MERIDIAN RANCH: ESTATES AT ROLLING HILLS RANCH NO. 2

PUD DEVELOPMENT, PRELIMINARY PLAN AND FINAL PLAT

LETTER OF INTENT

REVISED OCTOBER 2020

ESTATES AT ROLLING HILLS RANCH FILING 2
DEVIATION EXHIBIT
REX ROAD

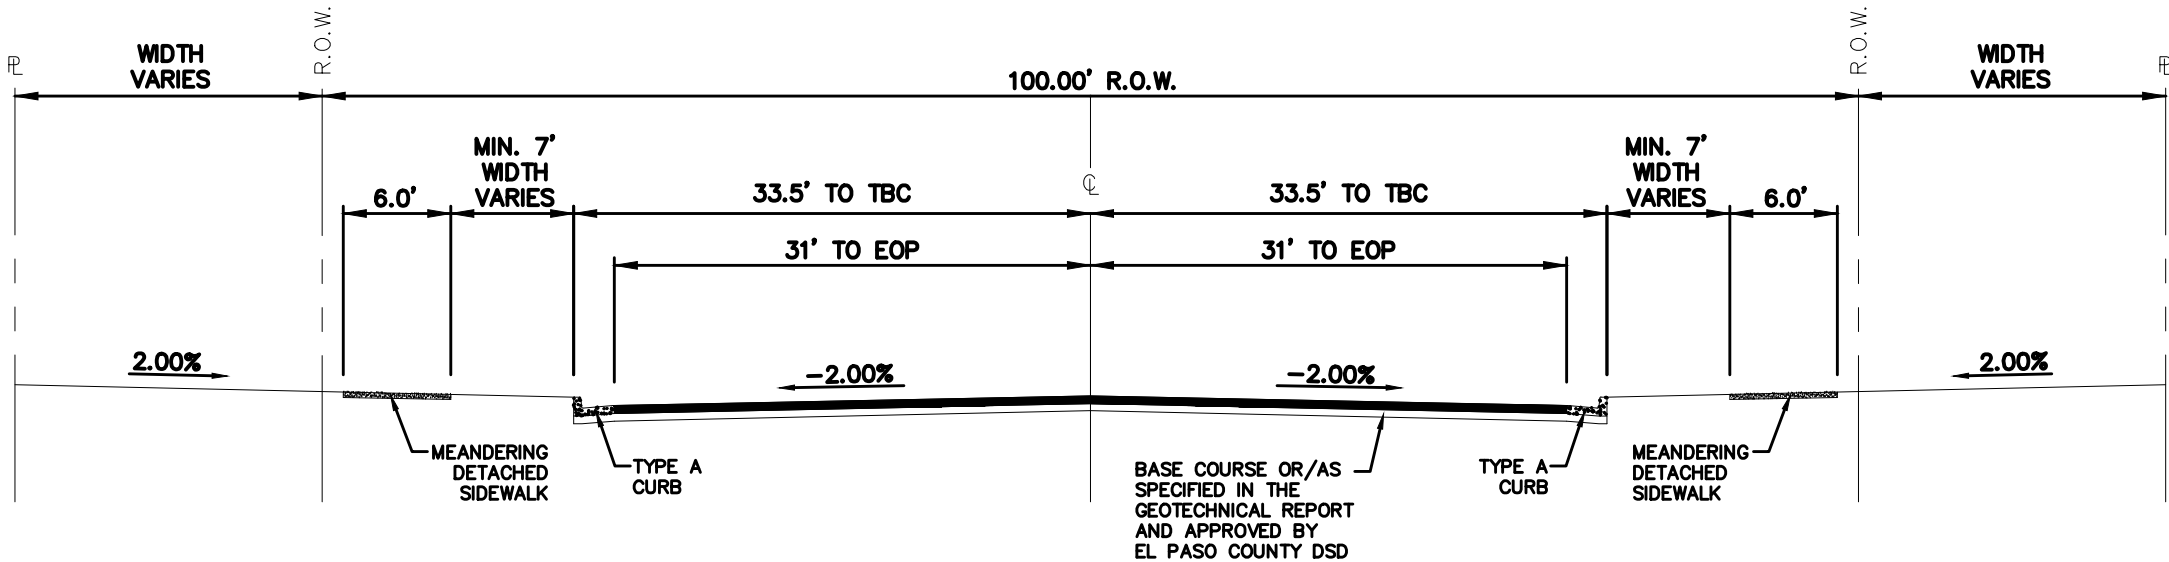
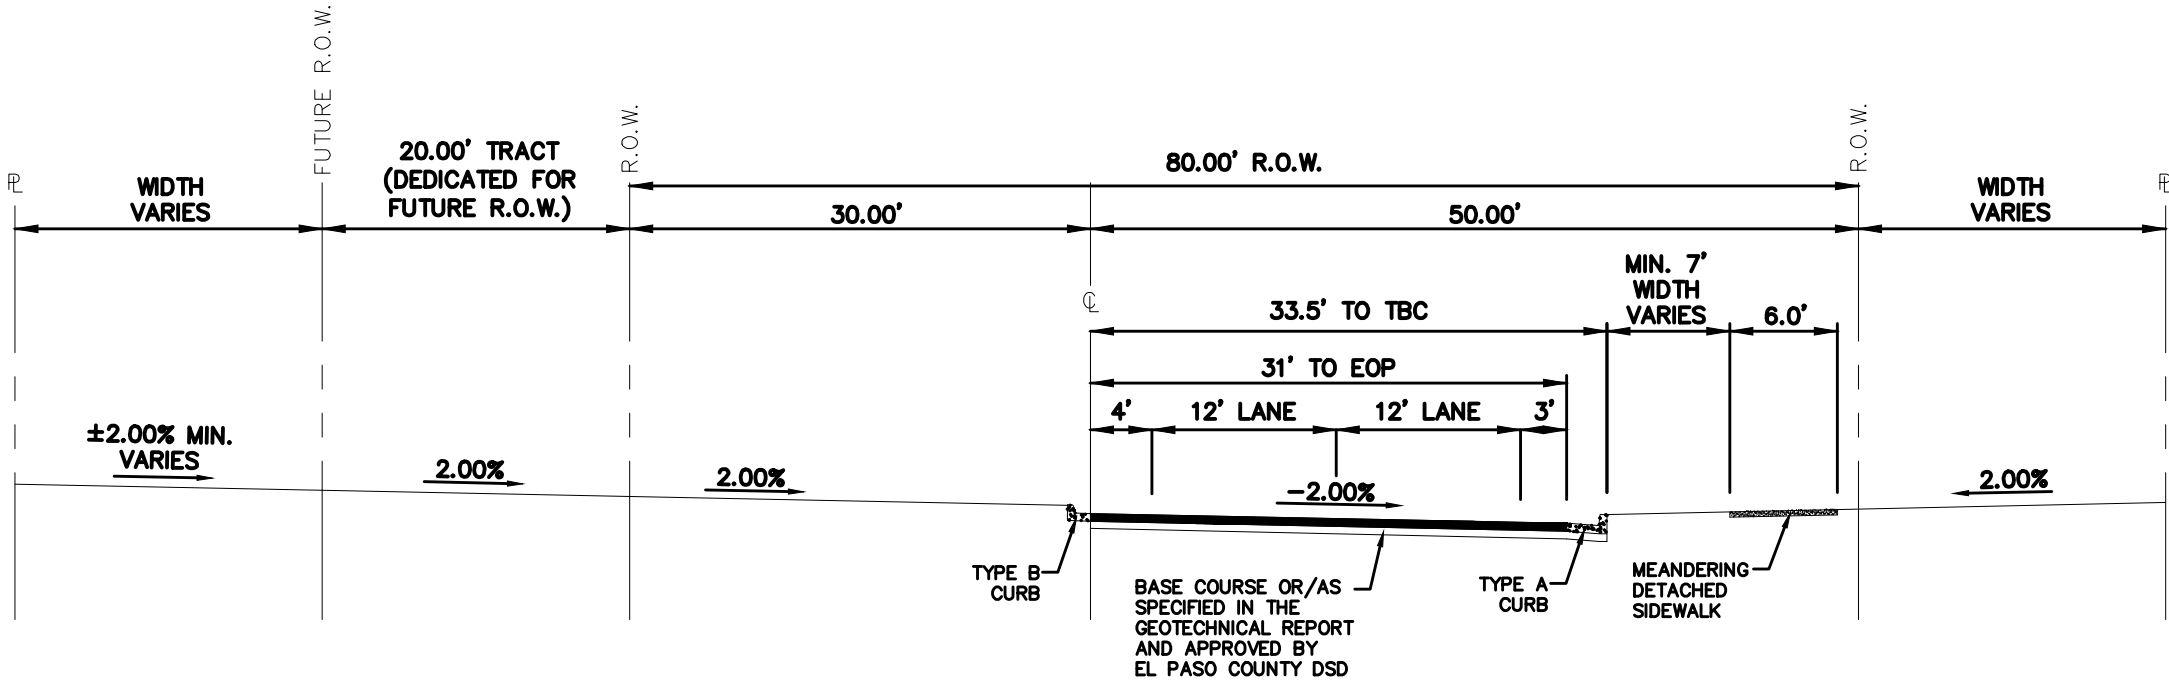
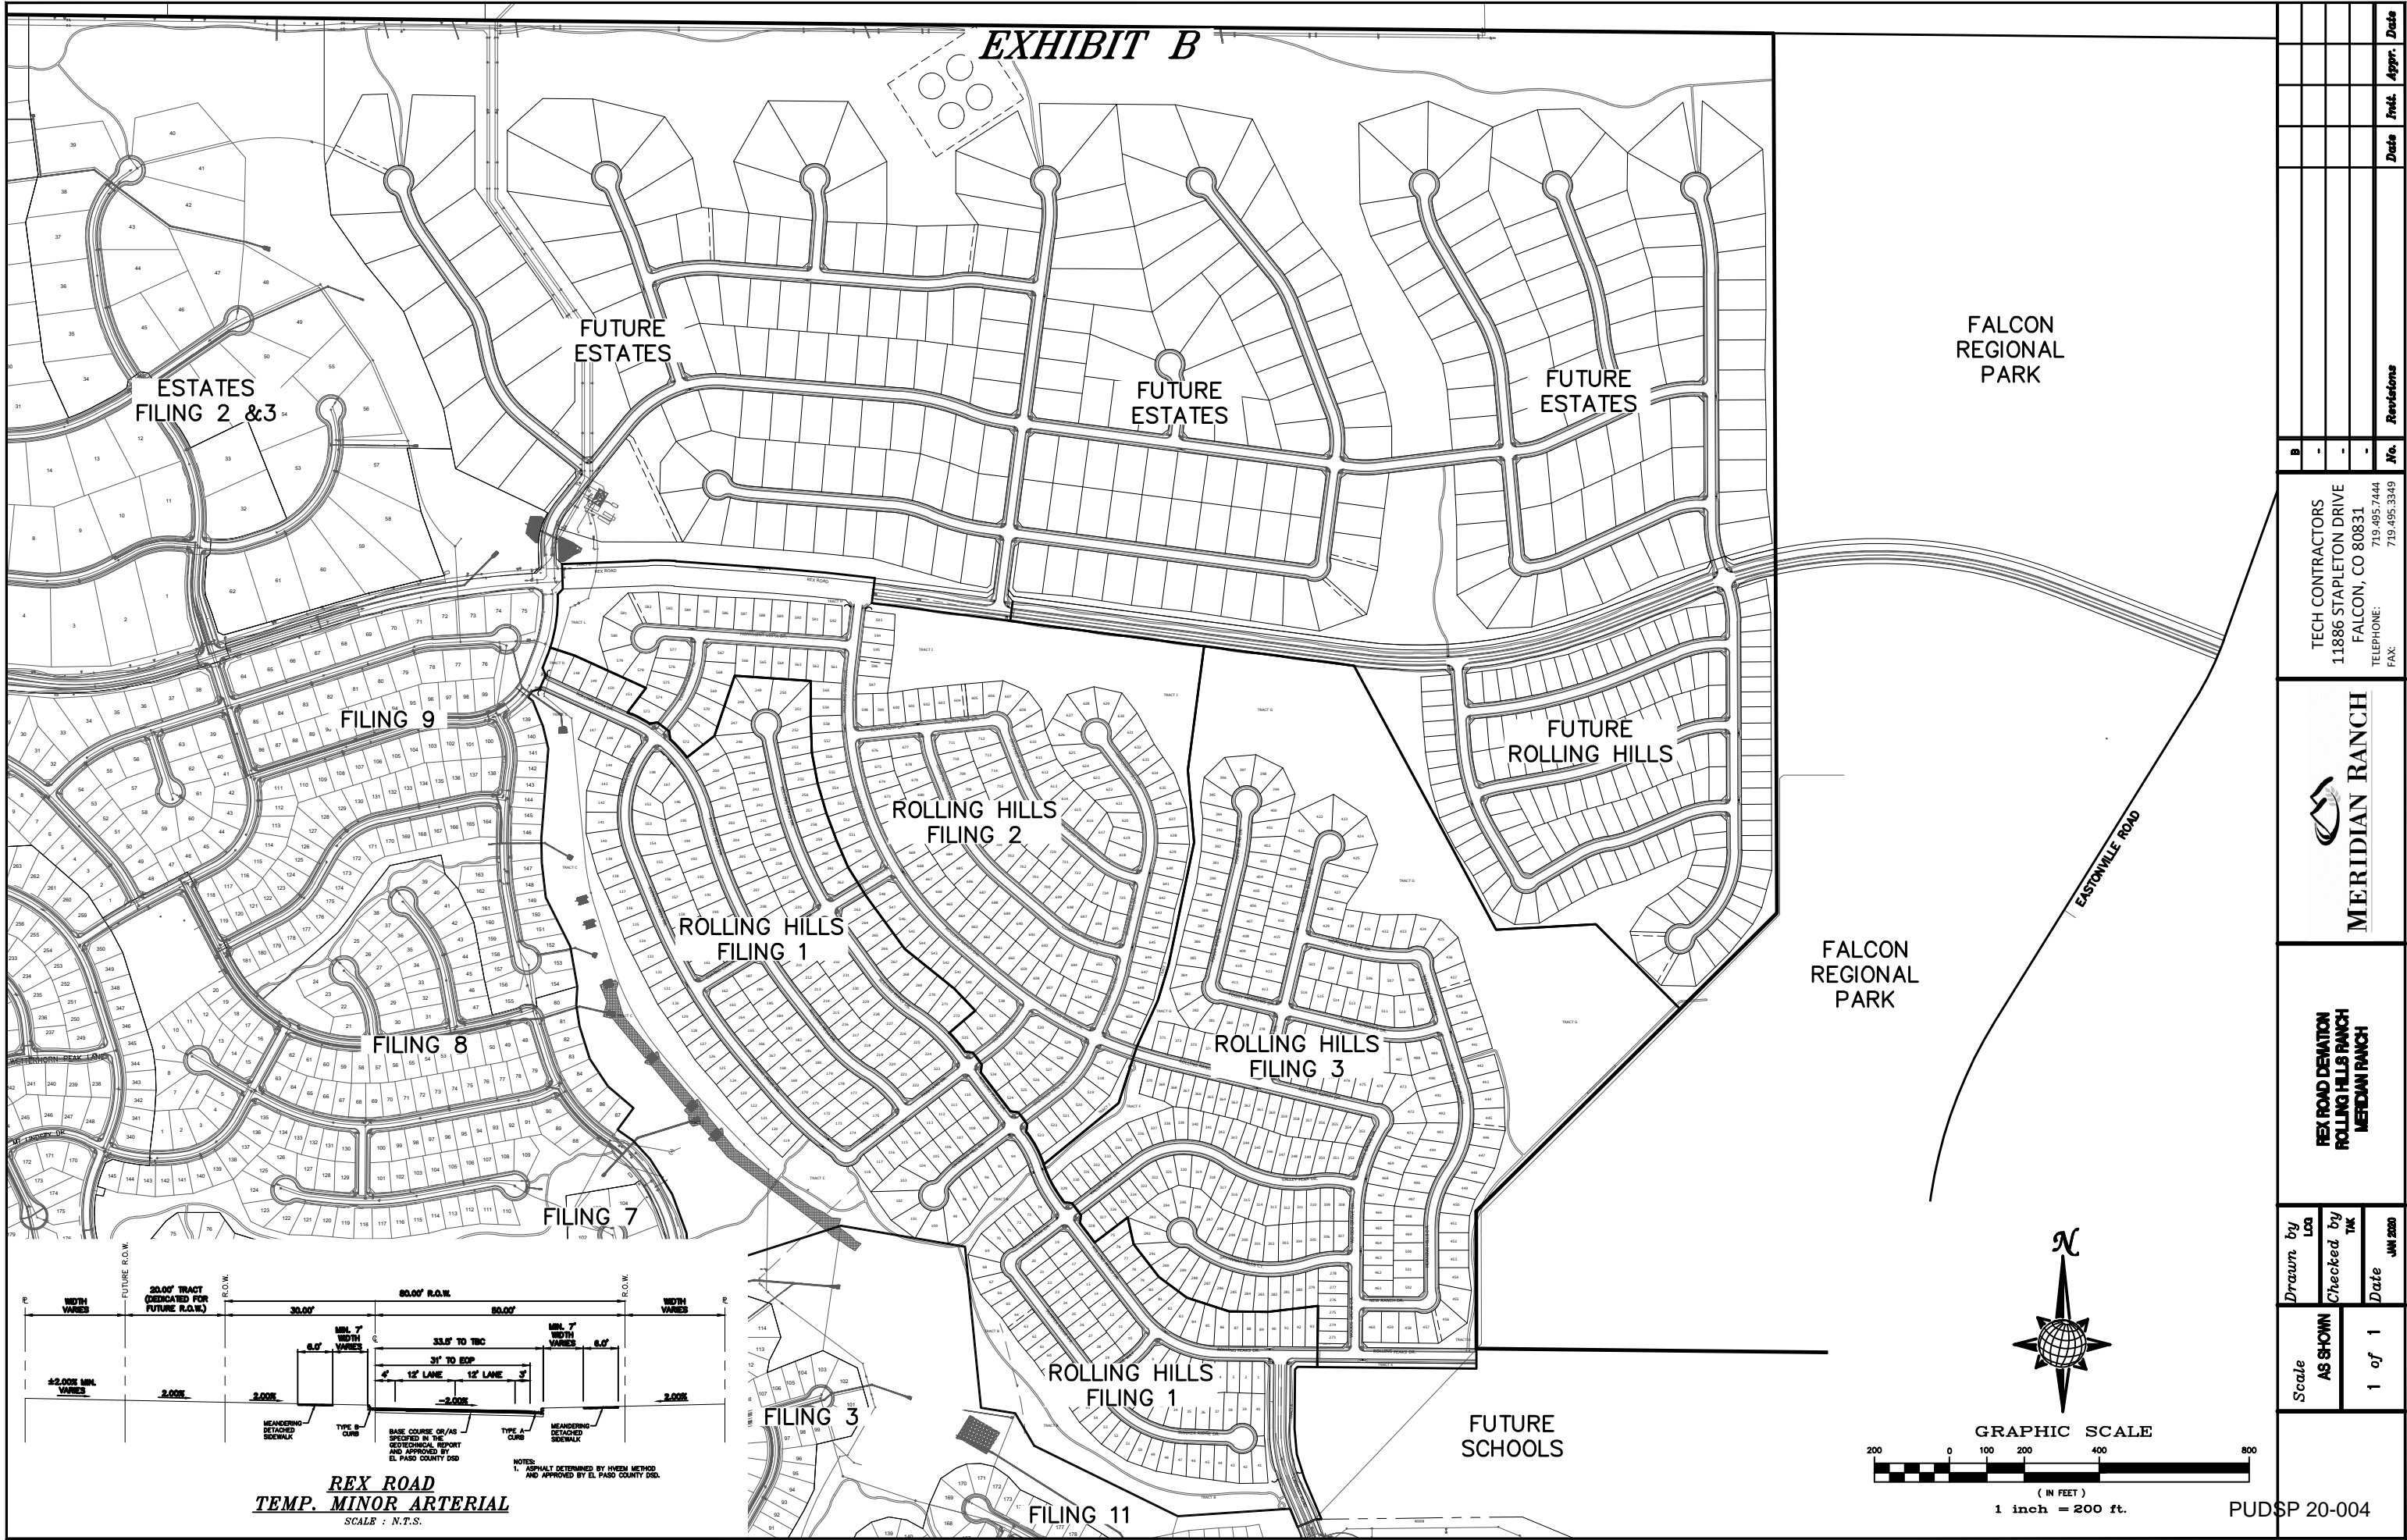
Review 1 comment: The PUDSP for Rolling Hills Ranch Filings 1-3 requested that the section of Rex Road to the east of Sunrise Ridge be constructed as a half section of the Urban Minor Arterial. This request is for it to be a Urban Residential Collector. Appendix A below also has information that this be a half section. Please revise this modification accordingly.
Review 2: Please revise this section to match what was approved with PUDSP199. Please see excerpt from below from the letter of intent of PUDSP199.
